**KIRKLEES METROPOLITAN COUNCIL
INVESTMENT & REGENERATION SERVICE**

Reference No: 2021/62/93265/W

Site Address: 29, Deer Croft Crescent, Salendine Nook,
Huddersfield, HD3 3SG

Description: Erection of extensions and alterations

Project: Extensions and Alterations 29 Deer Croft Crescent, Oakes HD3 3SG	Status:	Planning
	Date:	July 2021
	Scale:	1:100
	Drg No:	DCC06.A
Title: Proposed Plans		
#

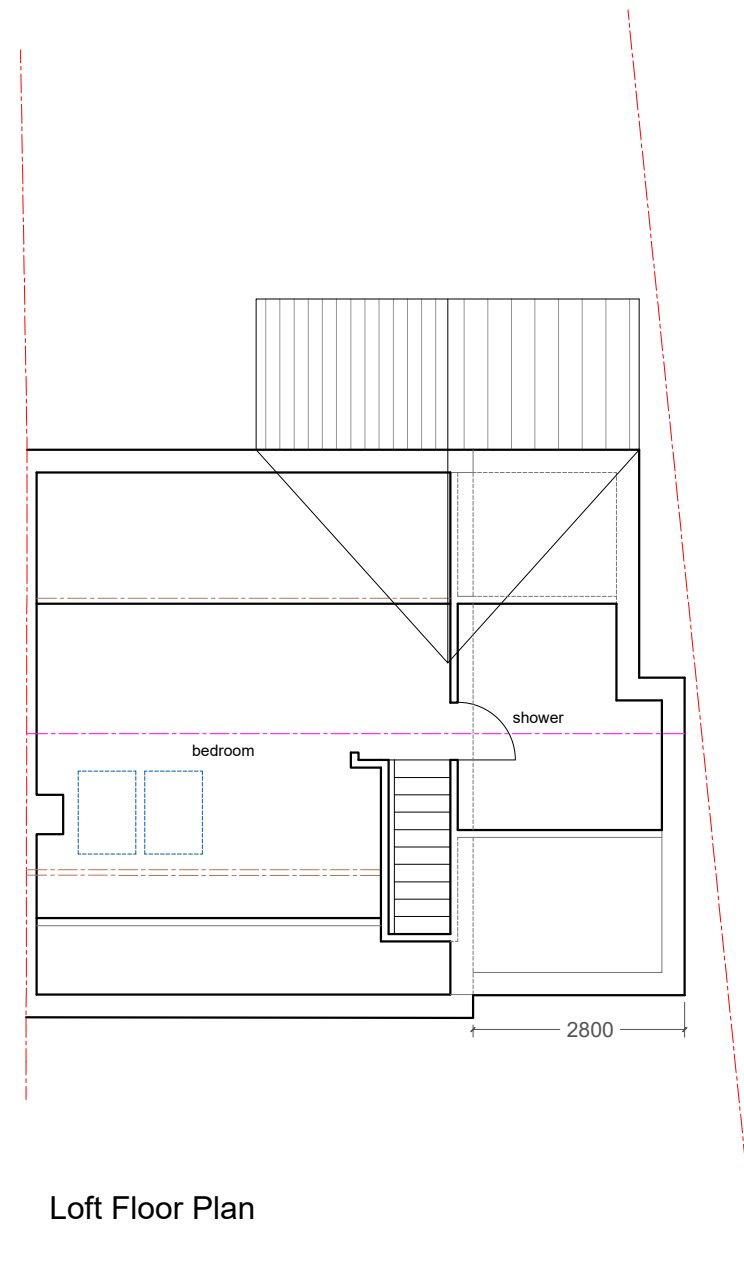
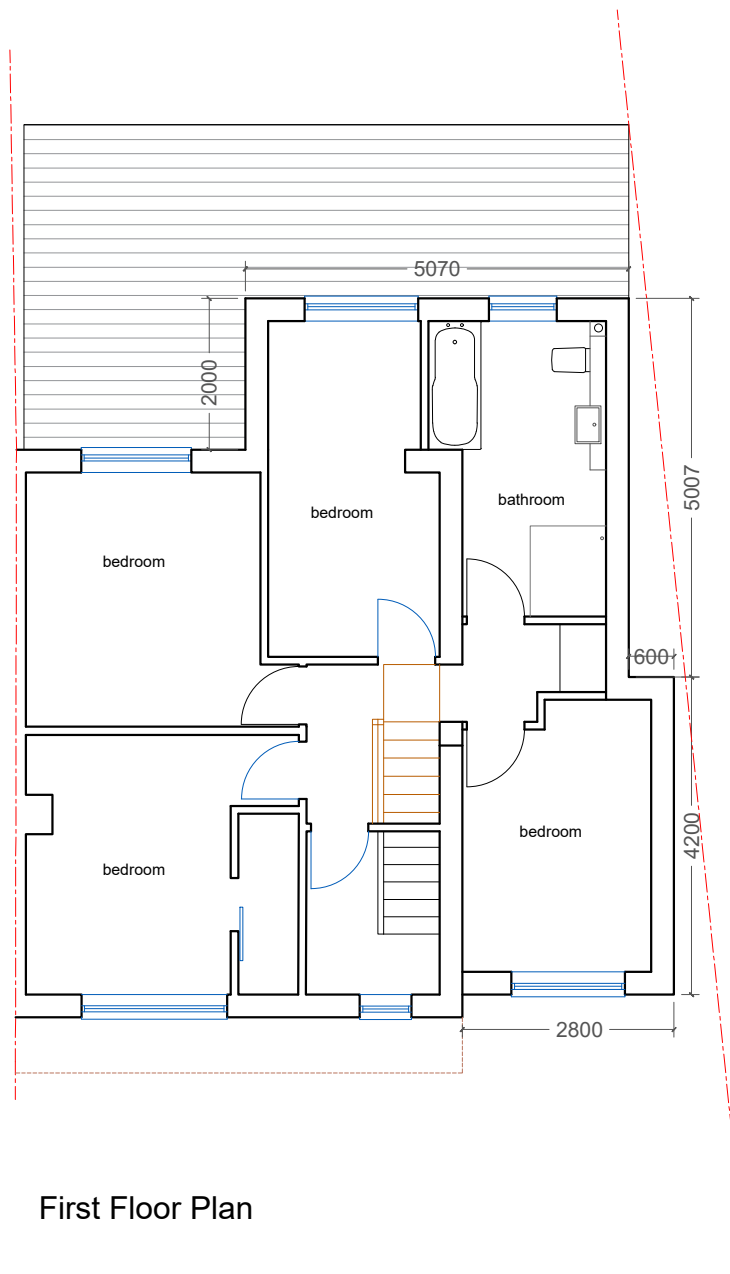
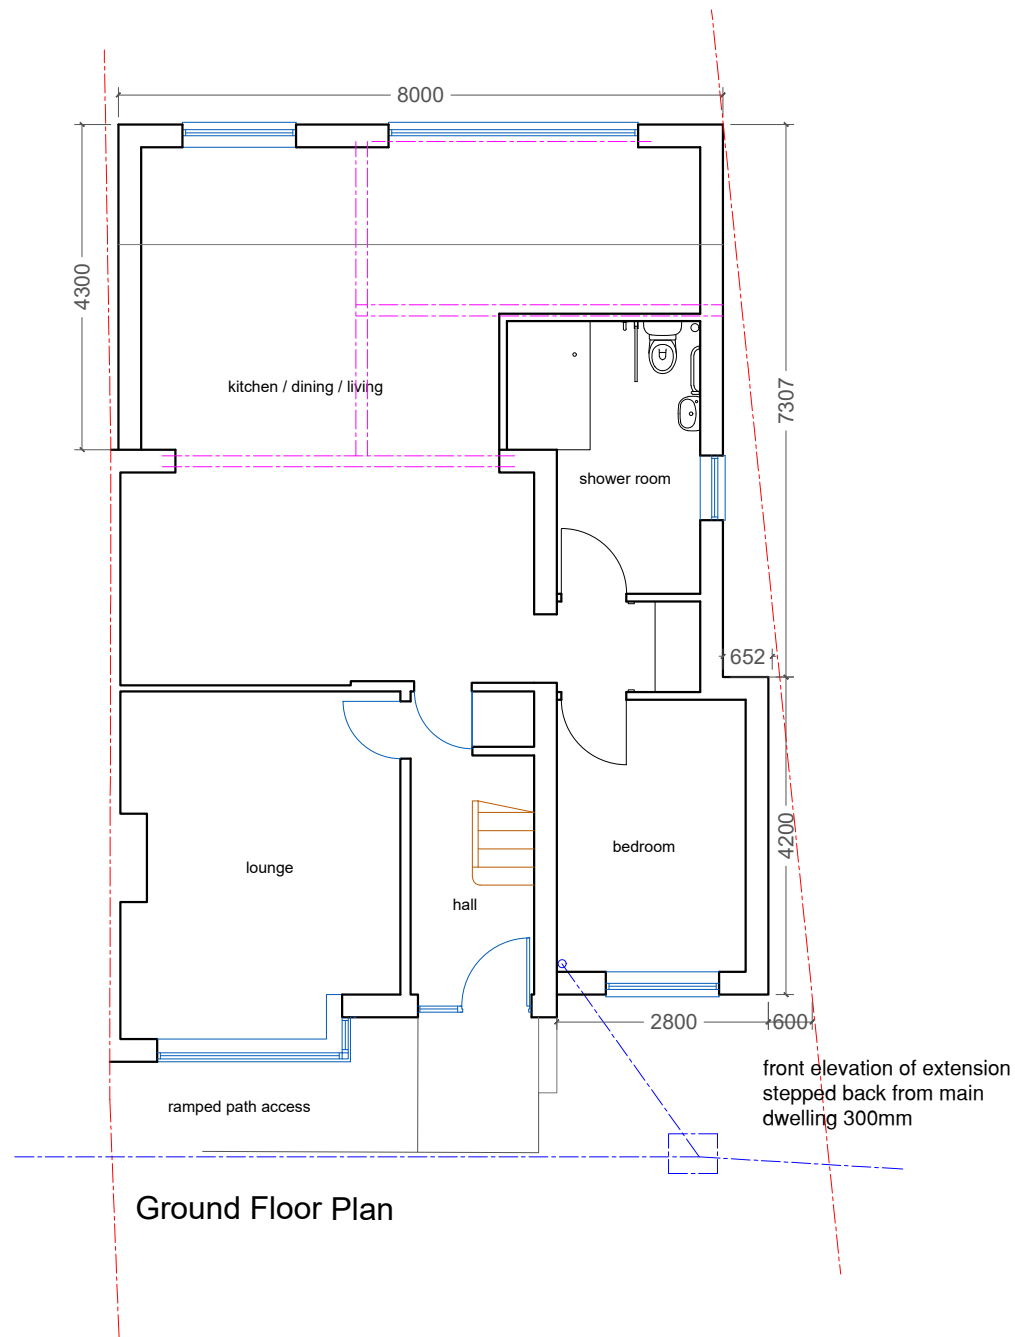
Officers raised concerns with the initial plans, especially in relation to the scale of the overall development, notably the bulk of the rear gable and the lack of subservience with the side extending element. In addition to this, Officers raised concerns with the lack of parking on-site to accommodate such development. The applicant amended the plans to address Officer concerns,

including the set back of the front wall of the side element, the reduction in height of the gable to the rear and the provision of parking to the front of the site.

Status:	Planning
		Date:	July 2021
		Scale:	1:100
		Drg No:	DCC07.A
		Title: Proposed Elevations #	
Project: Extensions and Alterations			
29 Deer Croft Crescent, Oakes HD3 3SG

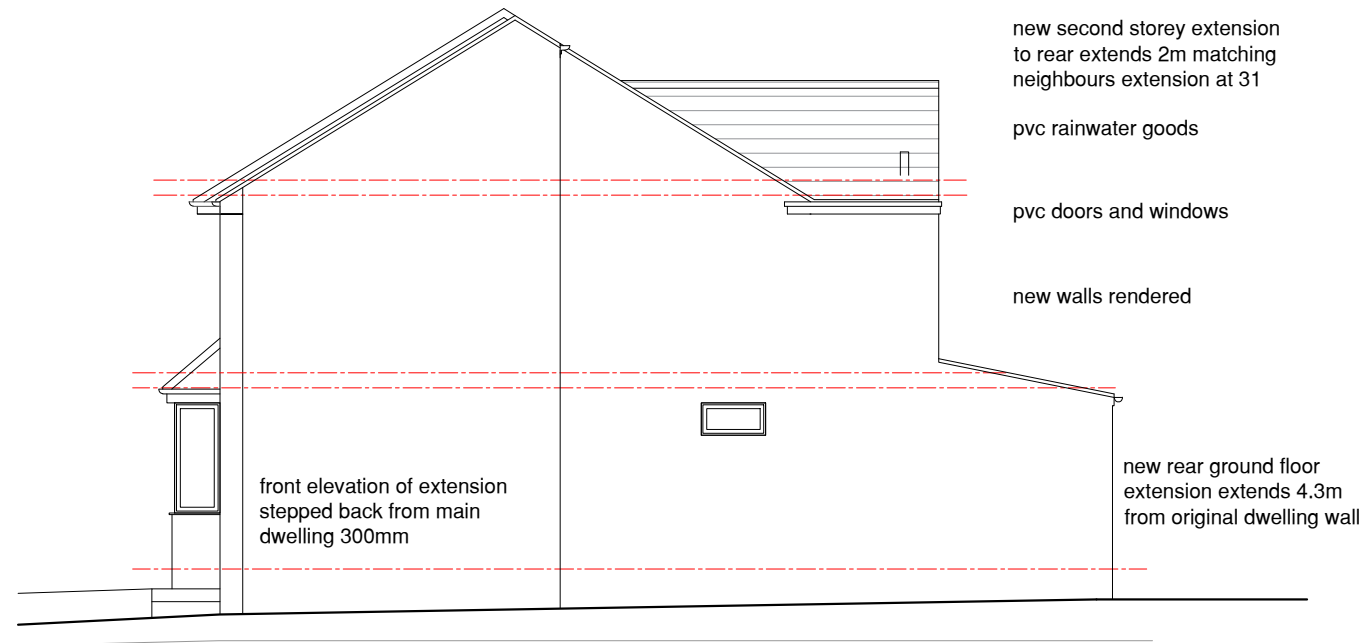
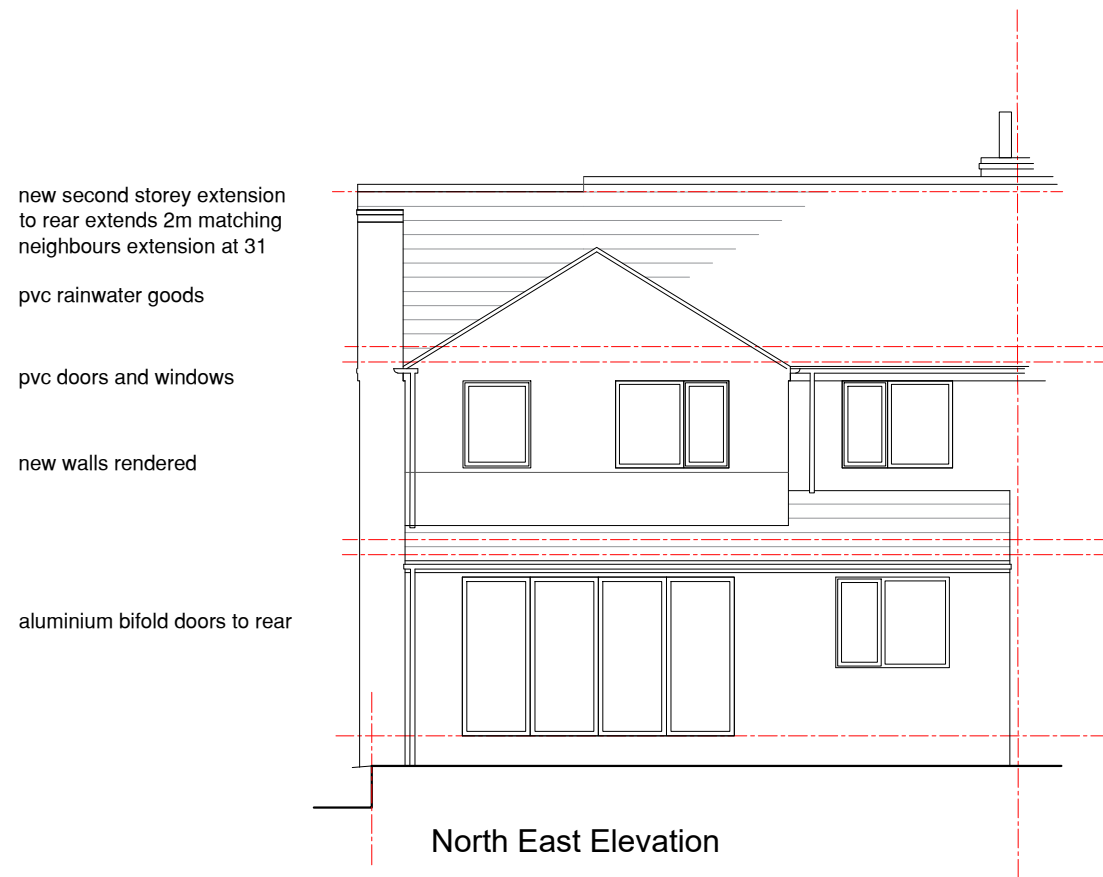
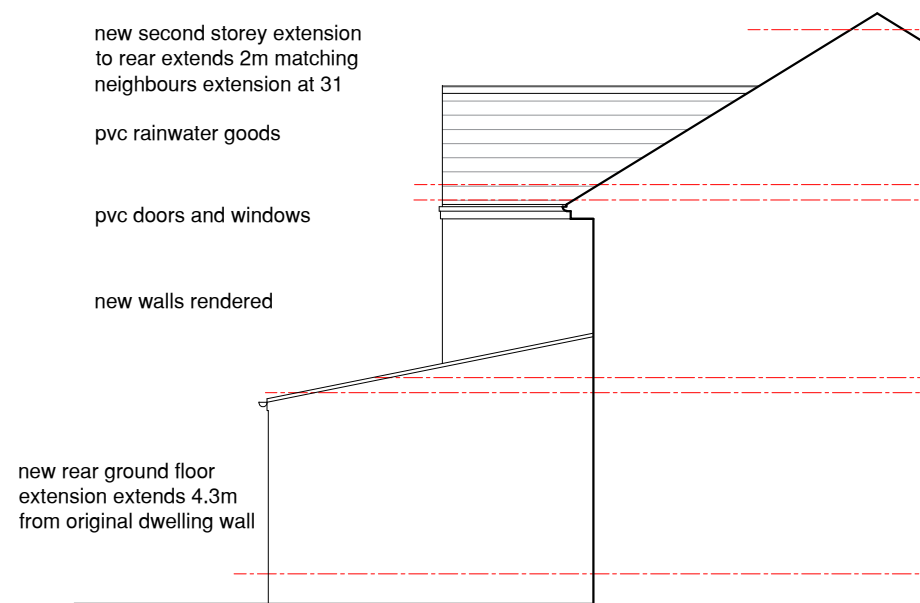
Officers raised concerns with the original proposal, especially in relation to the scale of the overall development, notably the bulk of the rear gable and the lack of subservience with the side extending element. In addition to this, Officers raised concerns with the lack of parking on-site to accommodate such development. The applicant amended the plans to address Officer concerns, including the set back of the front wall of the side element, the reduction in height of the gable to the rear and the provision of parking to the front of the site.

That said, a number of these guidelines are considered to be in place to protect the amenities of neighbouring properties which will be discussed in the next subsection. Further to this, the majority of the rear garden would still be retained as a result of the proposed rear extension, and this element of the proposal would not be highly visible from within the streetscene given its siting to the rear of the site, behind the buildings along Deer Croft Crescent. It is also considered that the extension to the rear would be relatively harmonious with the existing dwelling in terms of form and appearance. Of note, the gable extension proposed to the rear has been reduced in height during the processing of this application thereby reducing the bulk of this gable. This
